REFUSAL OF PLANNING PERMISSION

APPLICATION NO. 2014/1360

Proposal: Erection of 3 no. townhouses and a pair of semi-detached dwellings.
At: Land at Park Street, Wombwell, Barnsley

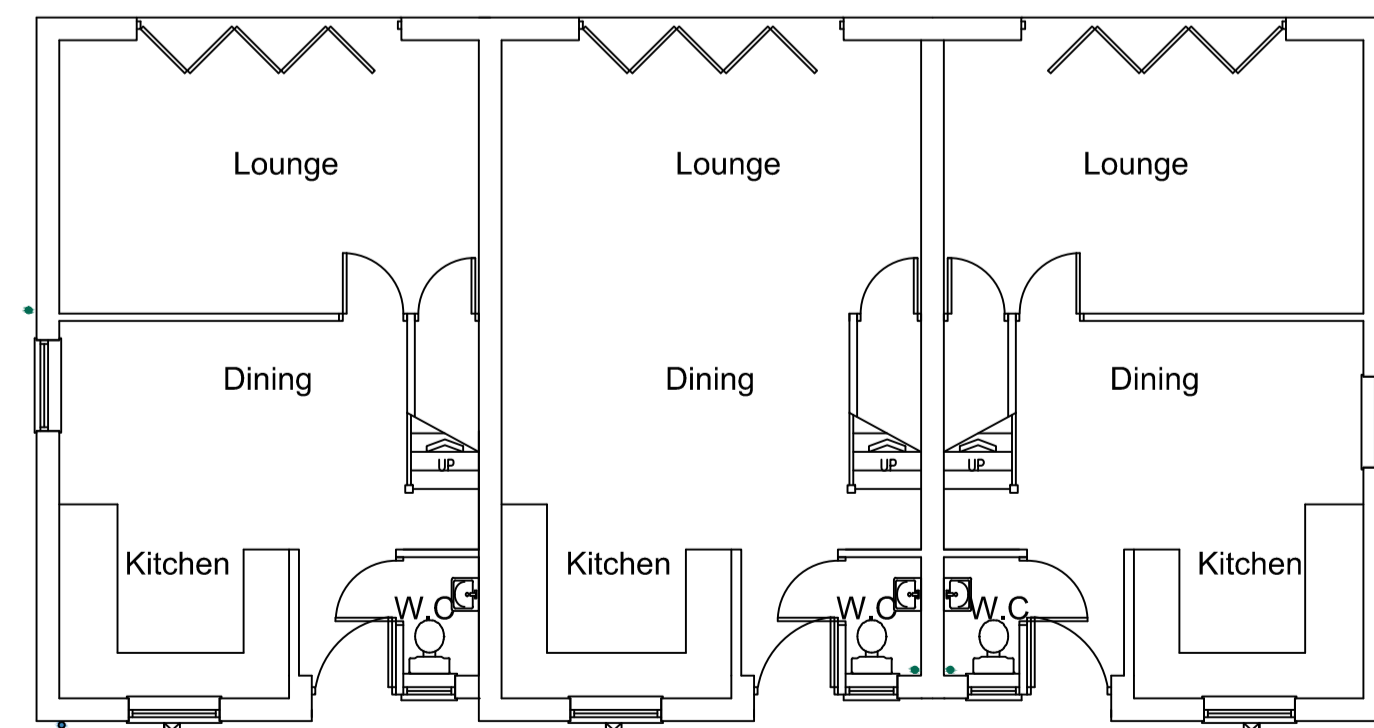
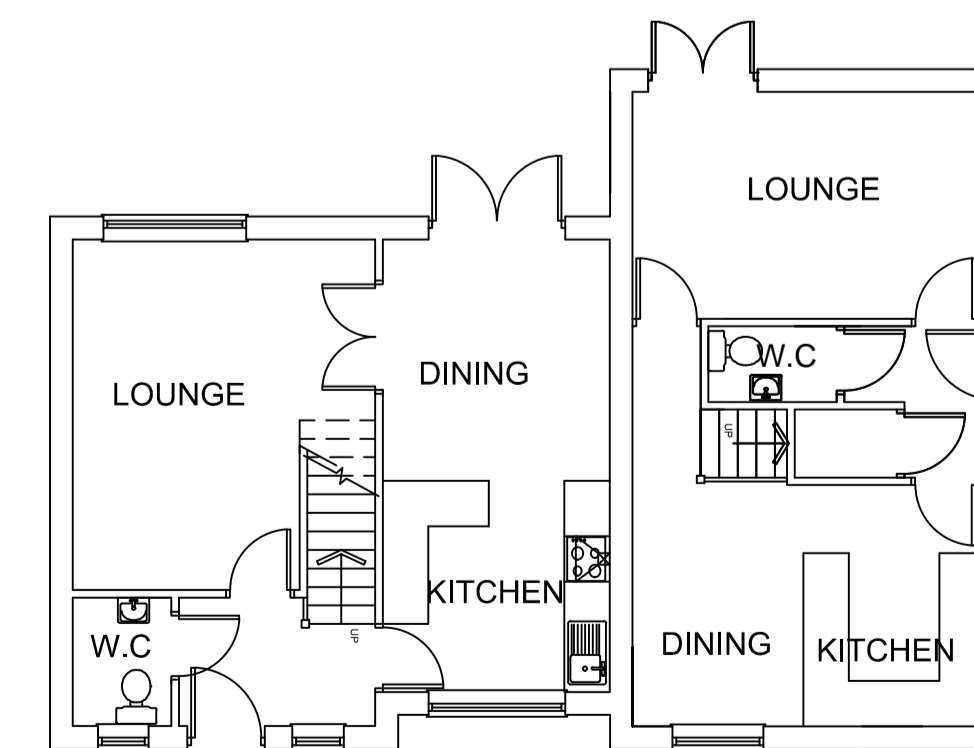
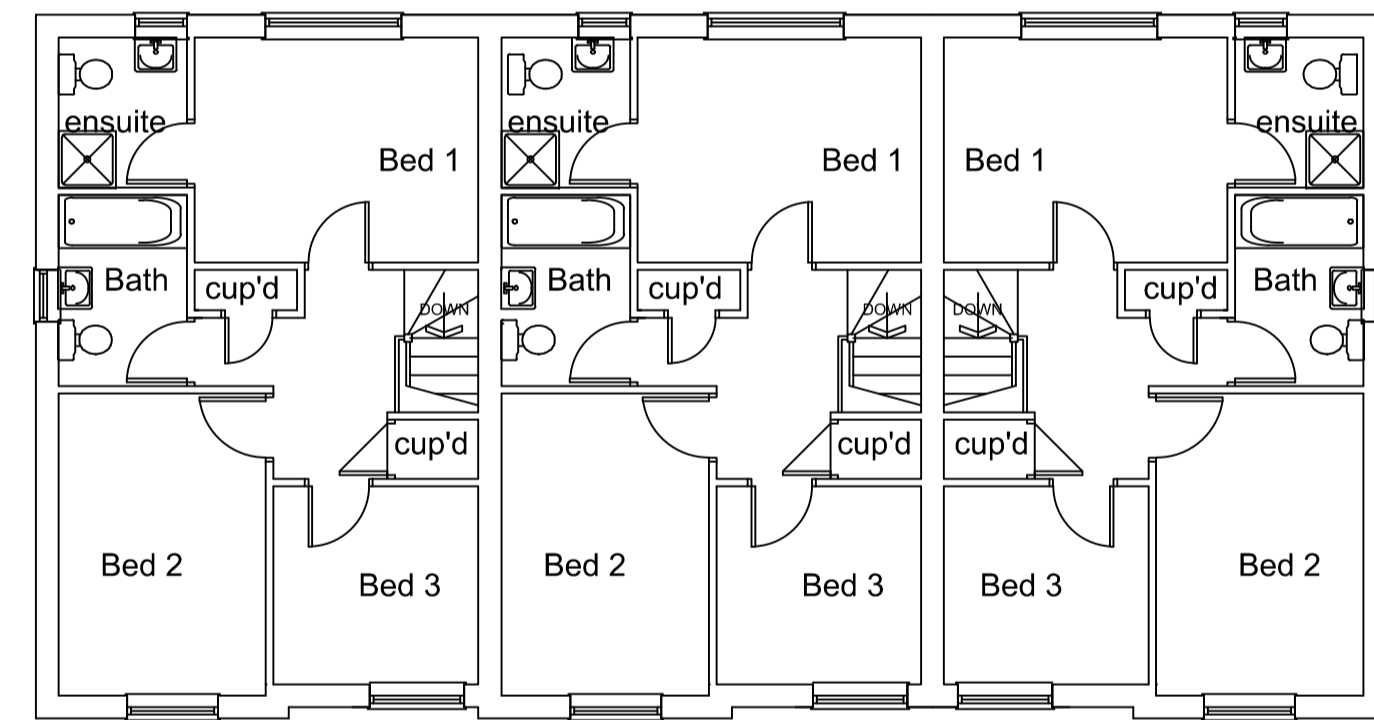
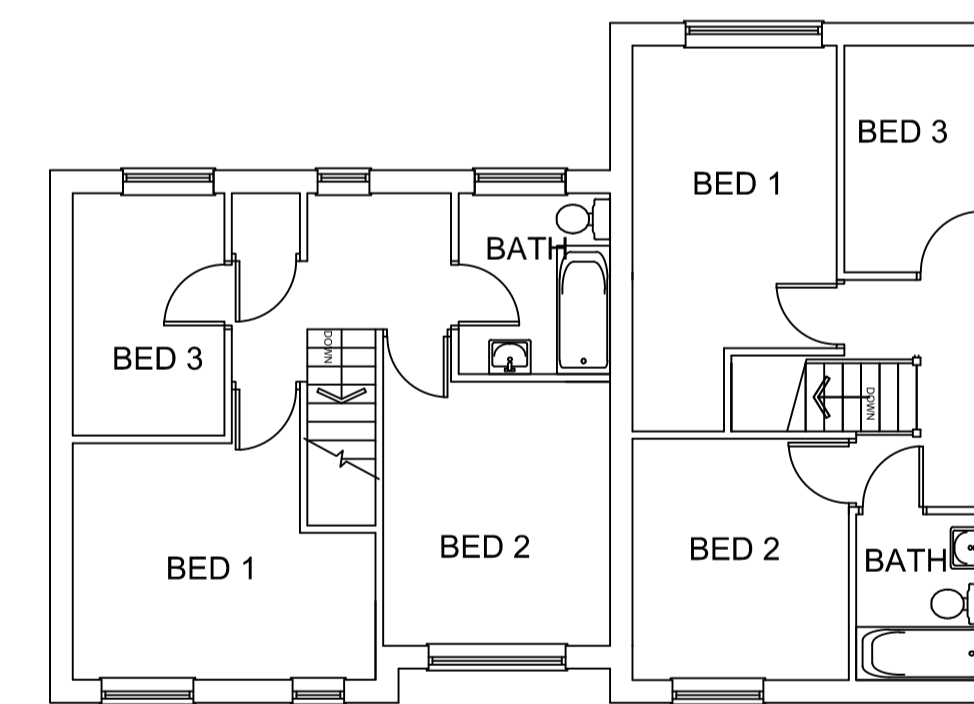
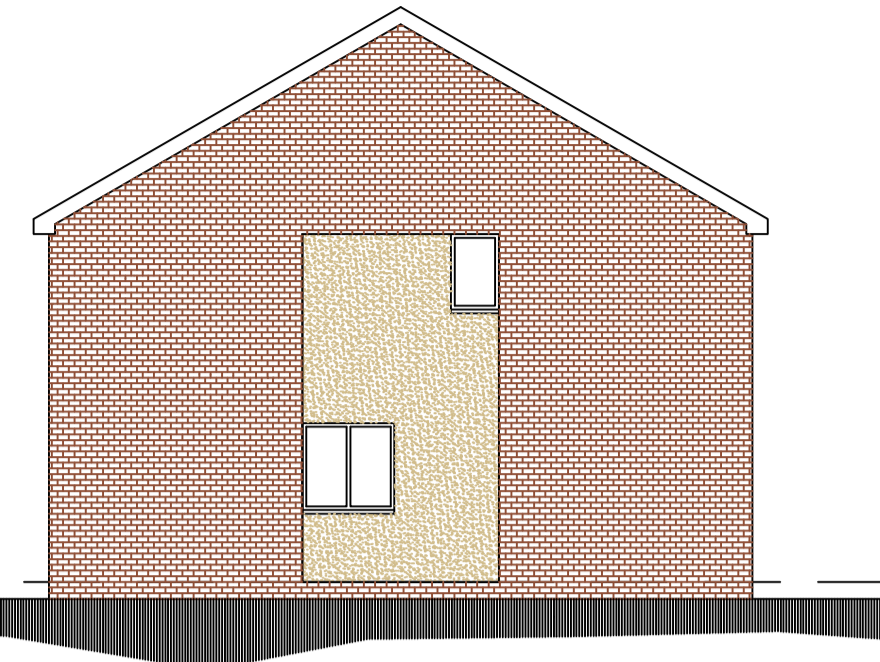
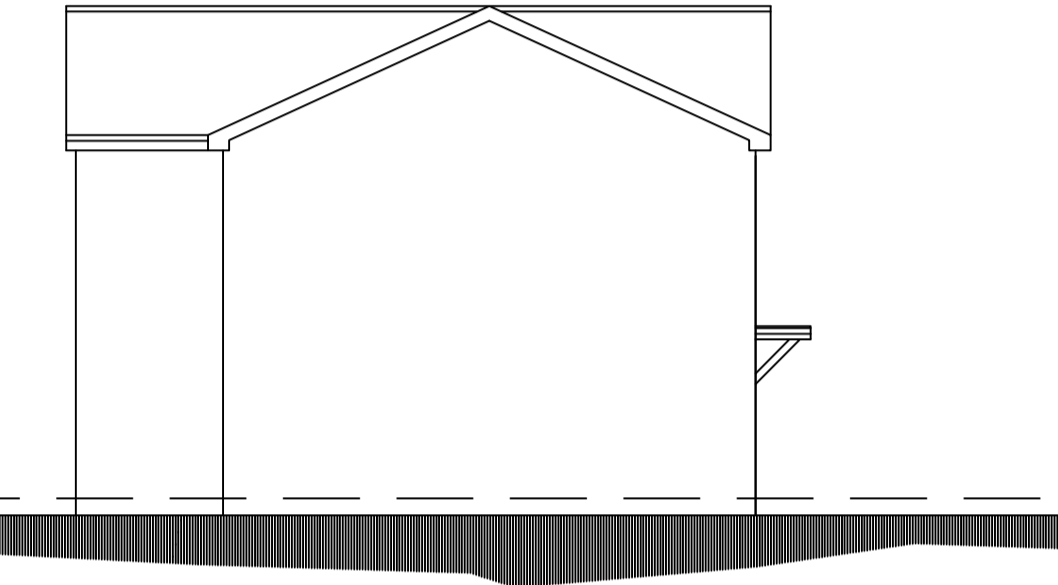
- 1 In the opinion of the Local Planning Authority, the proposal represents an over-developed layout resulting in a two storey property pushed to the front of the site, in a prominent position on the streetscene, and dwellings to the rear in an uncharacteristic 'backland' style layout, at odds with the character of the streetscene. This results in an awkward private amenity area to Plot1, close to the road and bounded by a hard 1.8m boundary fence at odds with the more open nature of existing front boundary treatment, a bland side gable elevation facing onto the access road from Plot 3, and amenity areas in close proximity to the adjoining school access and drop off area. As a consequence the scheme is considered to be of poor design that fails to take the opportunities for improving the character and quality of the area and the amenities of future residents contrary to UDP Saved policy H8D, paragraph 64 of the NPPF, UDP Saved policy H8D, CSP29 of the Core Strategy, and the Supplementary Planning Guidance "New Housing"
